CITY OF ALBUQUERQUE

February 6, 2019

**RE: Utility Trailer Sales
8201 Daytona Rd NW
Request for Certificate of Occupancy – Permanent
Engineer's Certification Date: 2/1/19 – Not Accepted
Grading Plan Stamp Date: 7/12/18
Drainage Report Stamp Date: 7/11/18
Hydrology File: K09D026B**

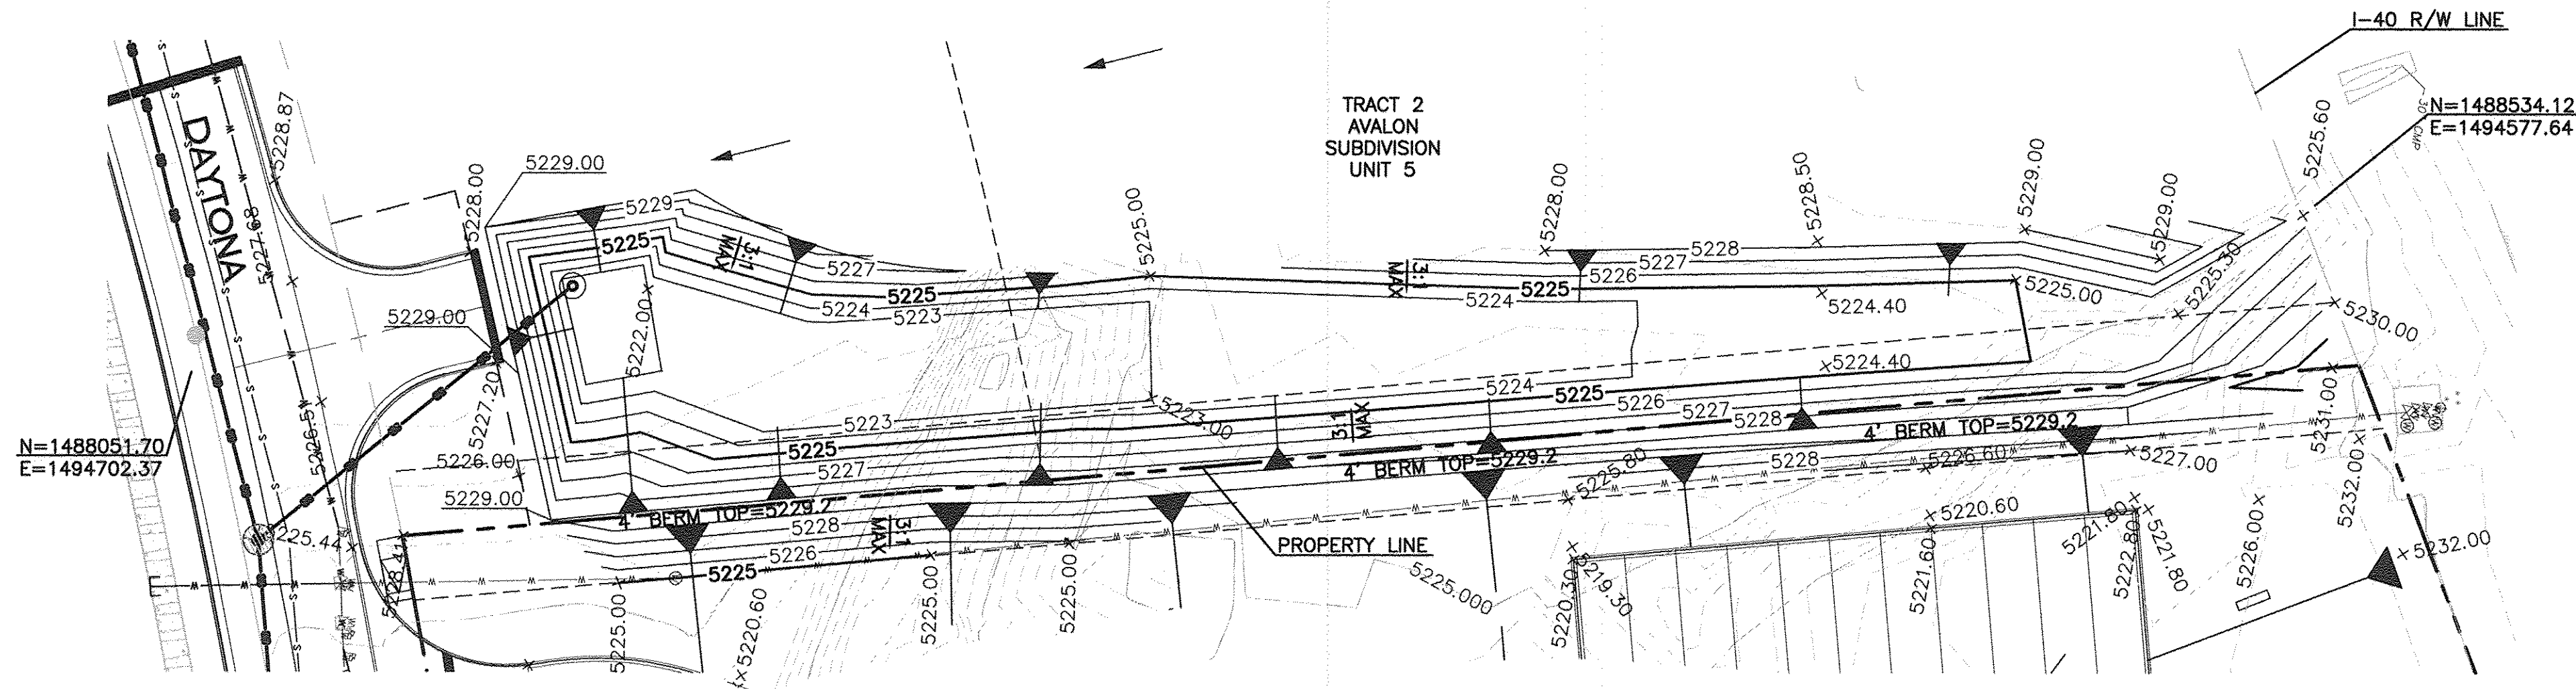
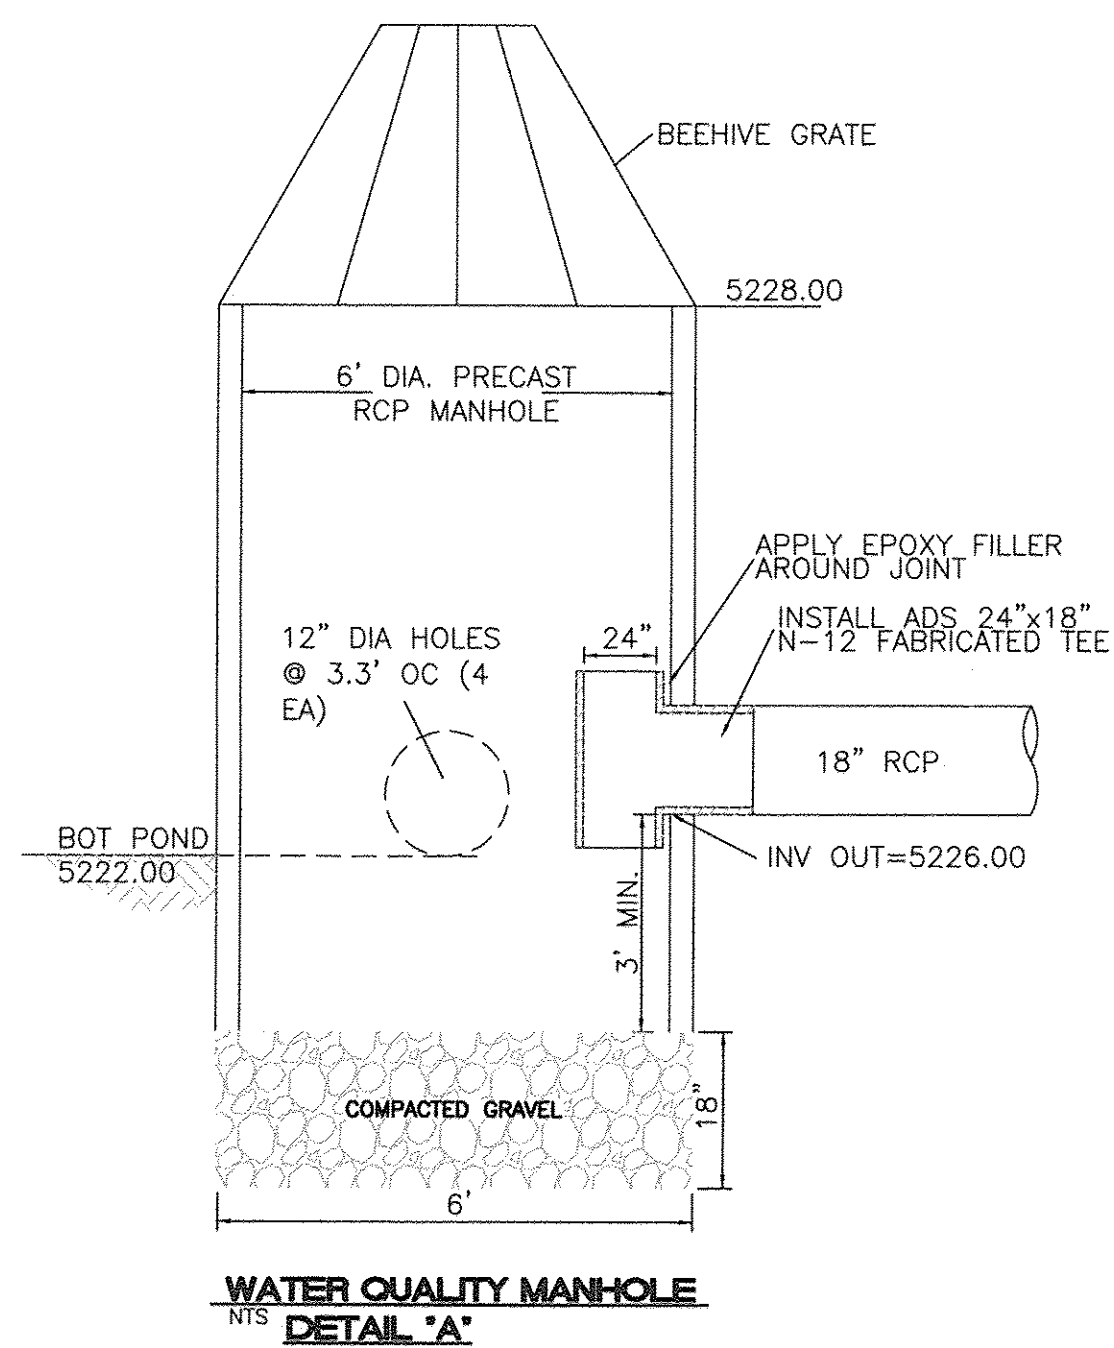
1. The berm along the west side of the property was constructed lower than the pipe outfall (5226.26') and emergency overflow (5228.18'). A revised design/detail will need to be provided to Hydrology to correct this issue (no fee for this activity, email a pdf of the revised design for approval). It is likely that the berm will need to be raised or the outfall reconfigured; ensure freeboard along the berm is considered (1' above the emergency overflow is recommended). Because this poses a significant hazard to the subject property, a Temporary C.O cannot be considered until corrected.

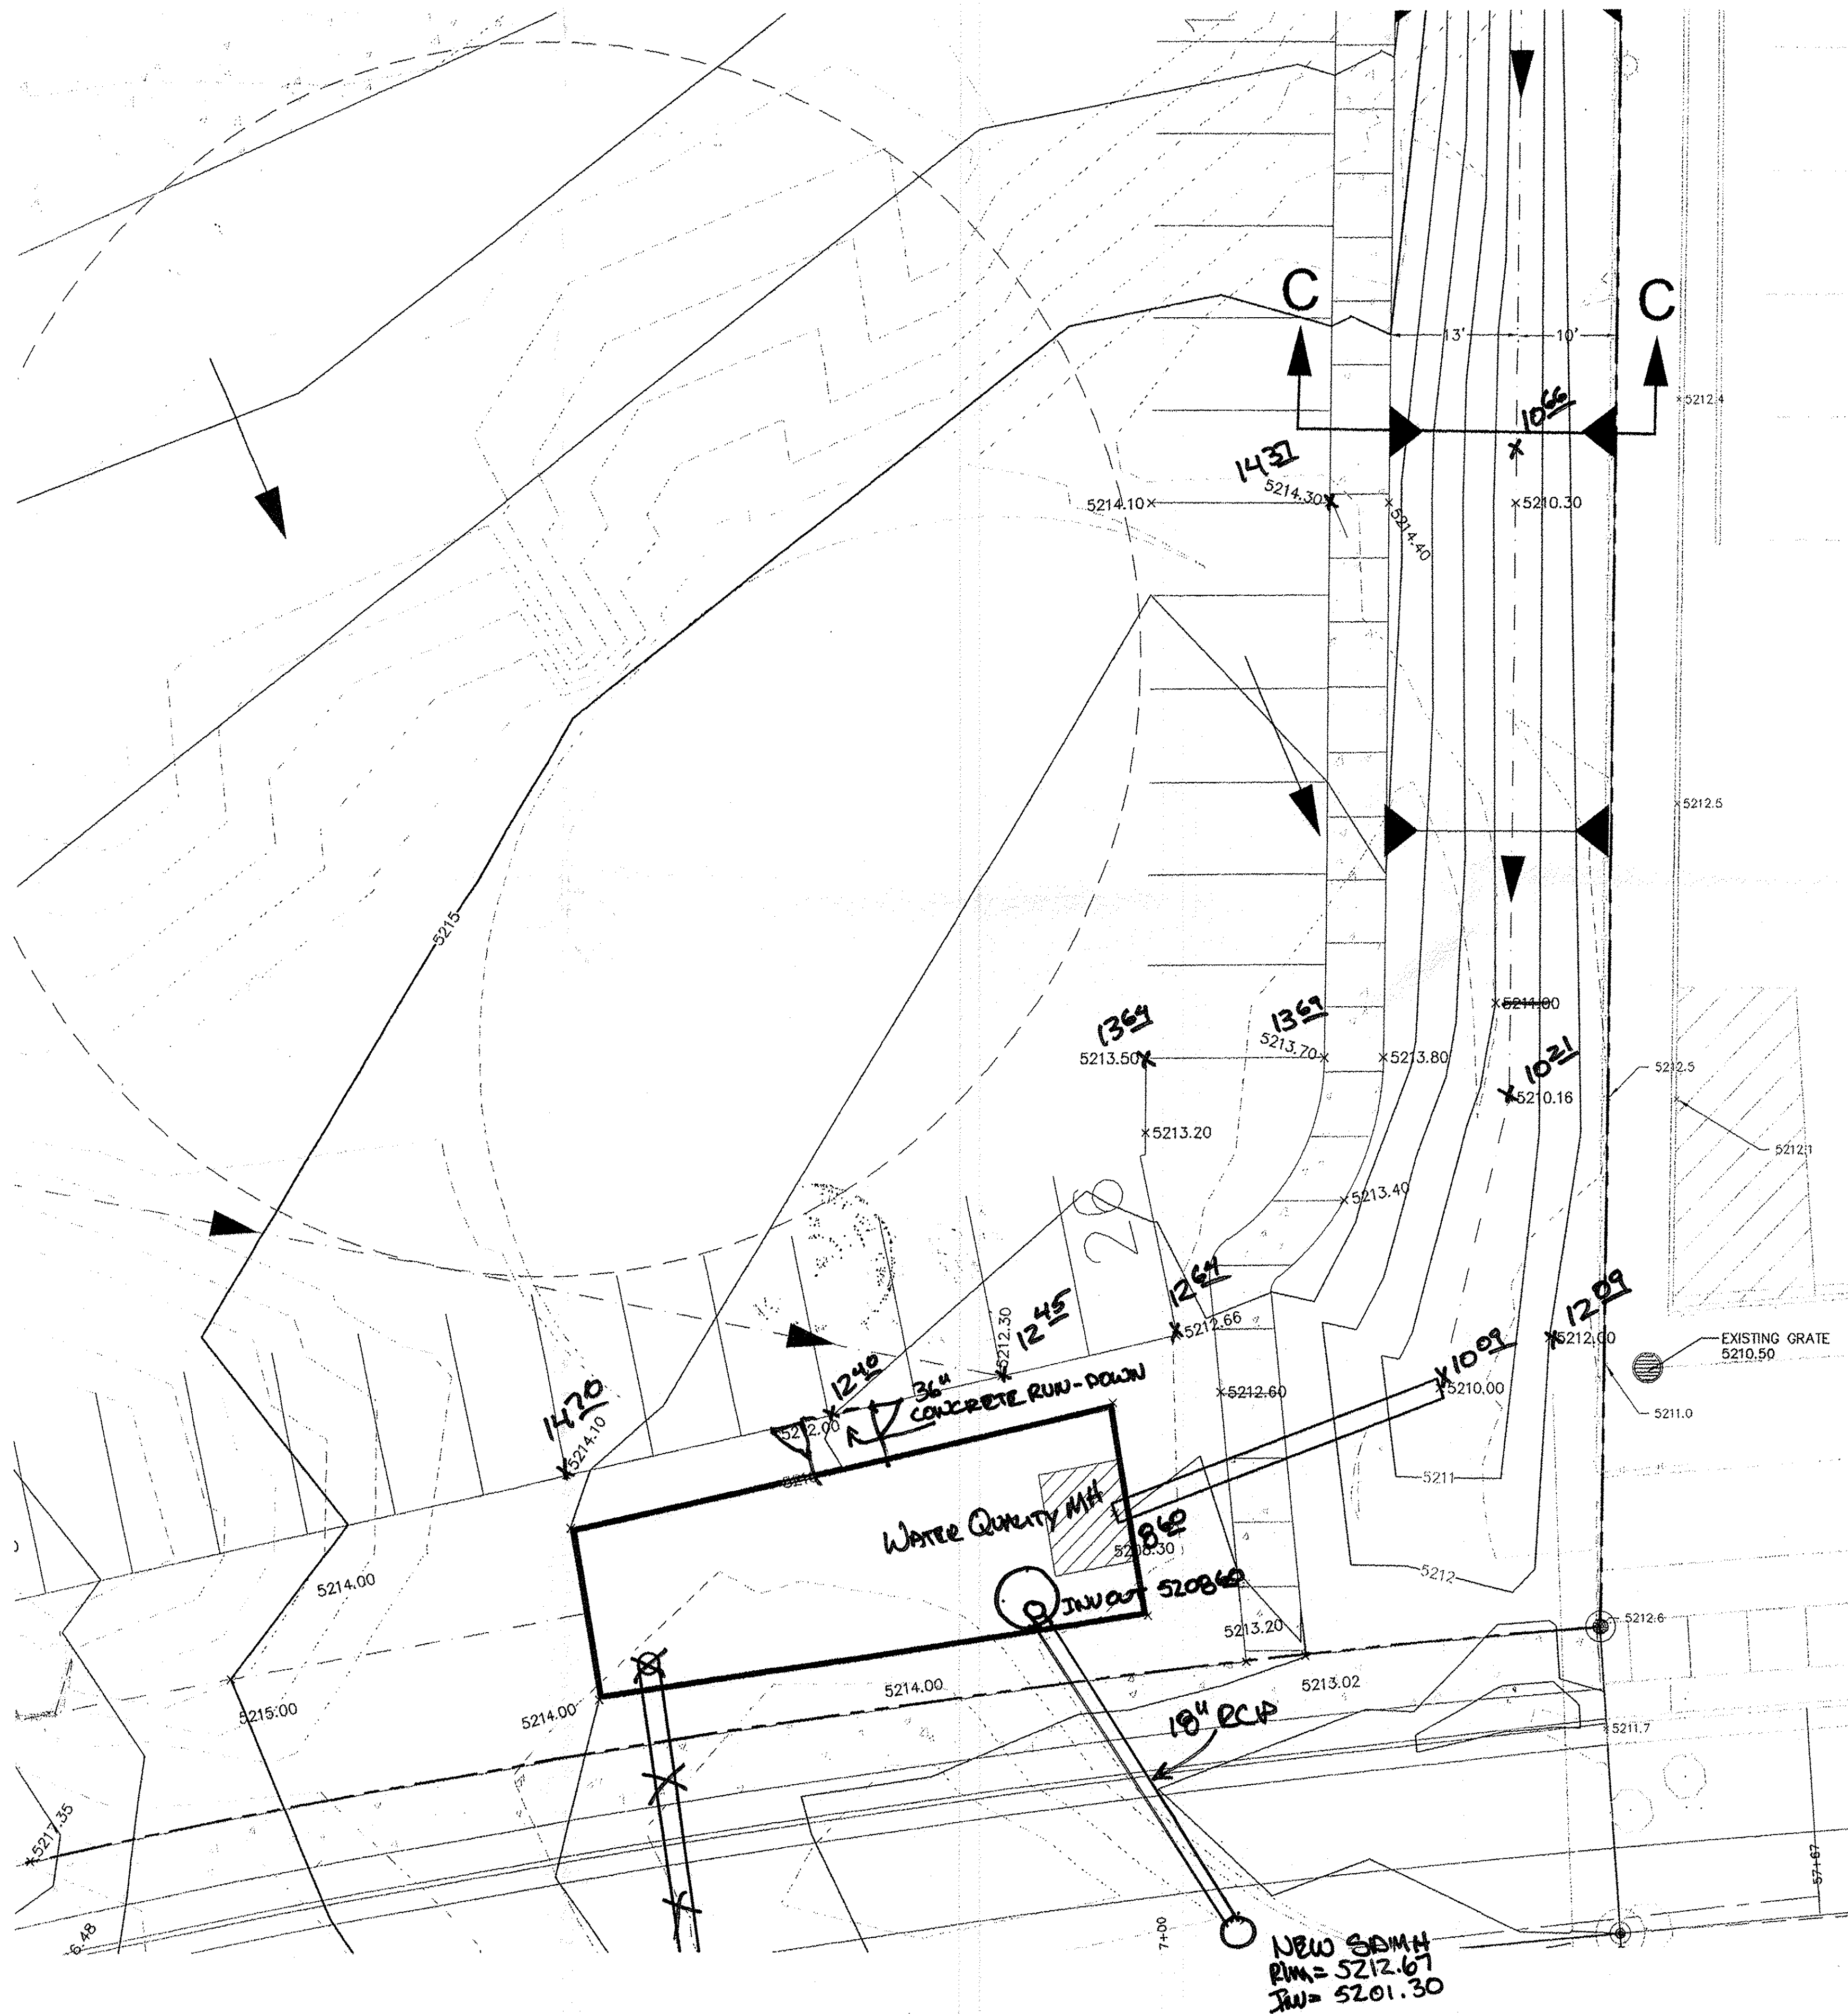
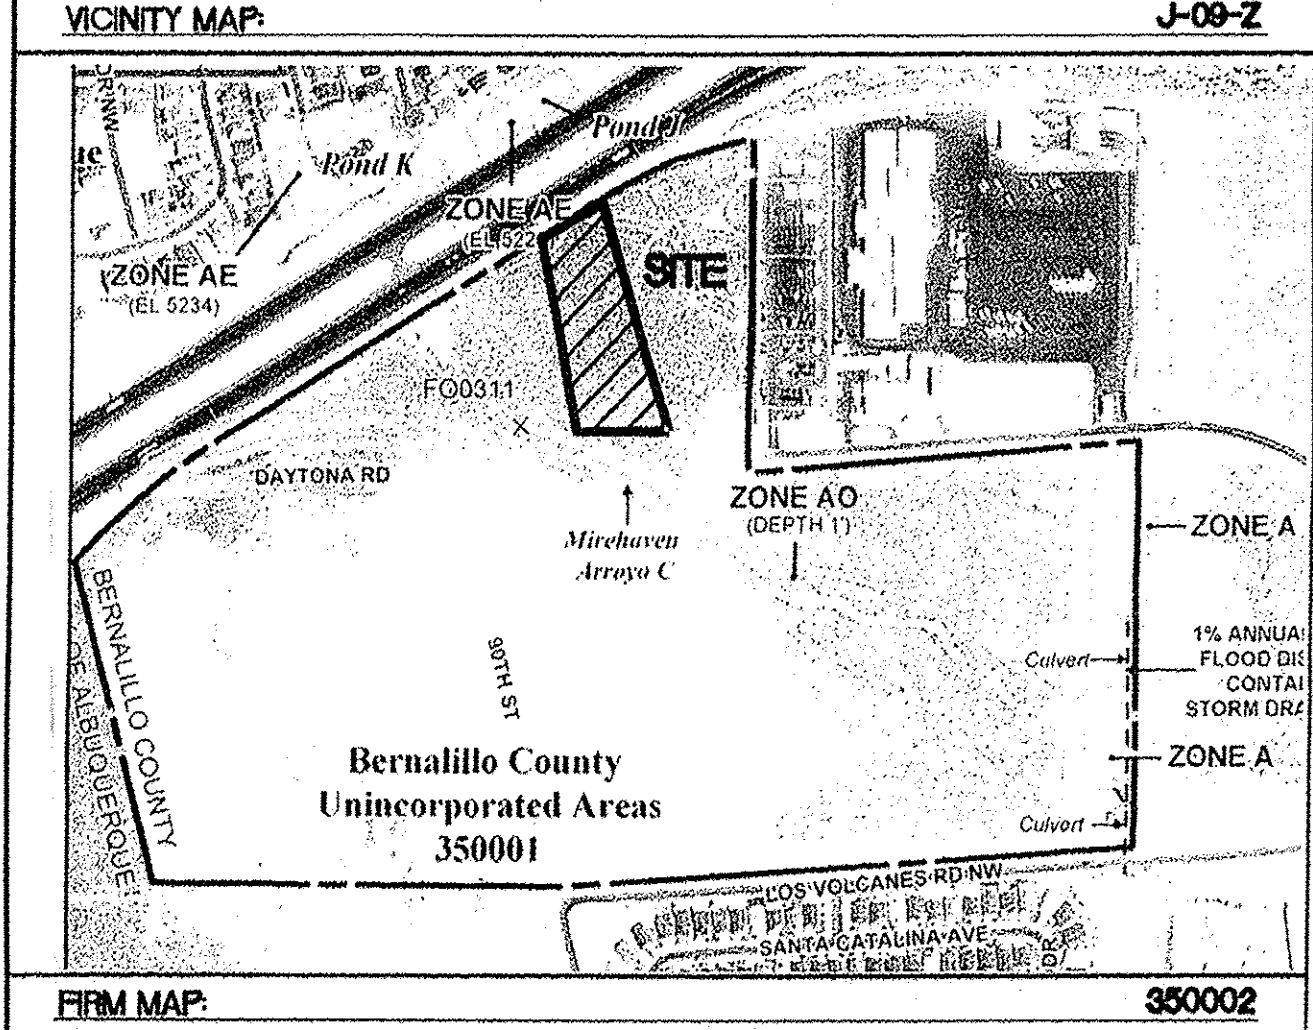
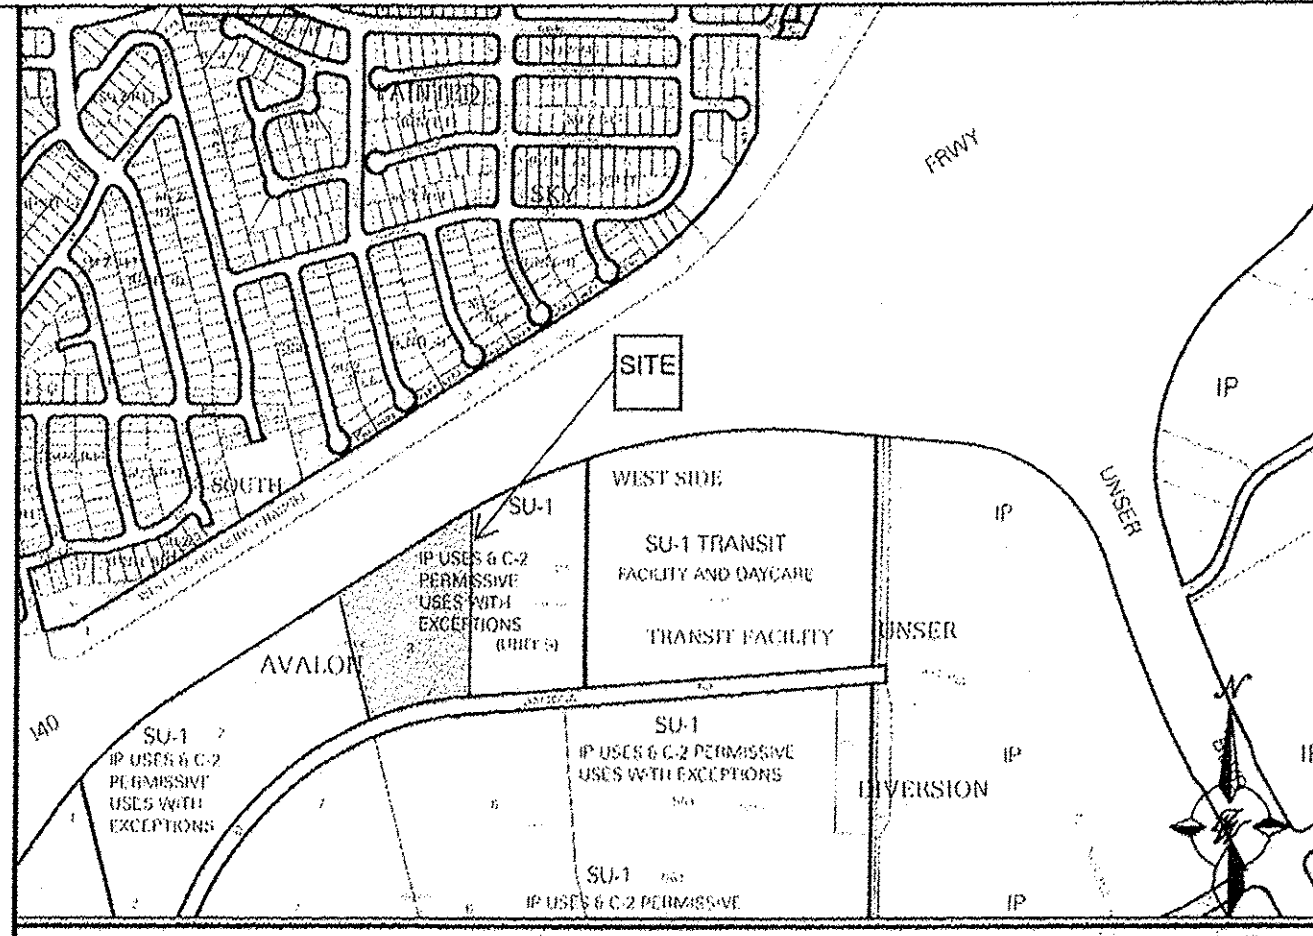
2. The outfalls from the west desilting pond and Pond B use PVC Pipe, not RCP; PVC is not permitted in the ROW. Provide confirmation that a transition to RCP is made at the ROW line. Provide during-construction photos, video, and post-construction photos as necessary to support this.
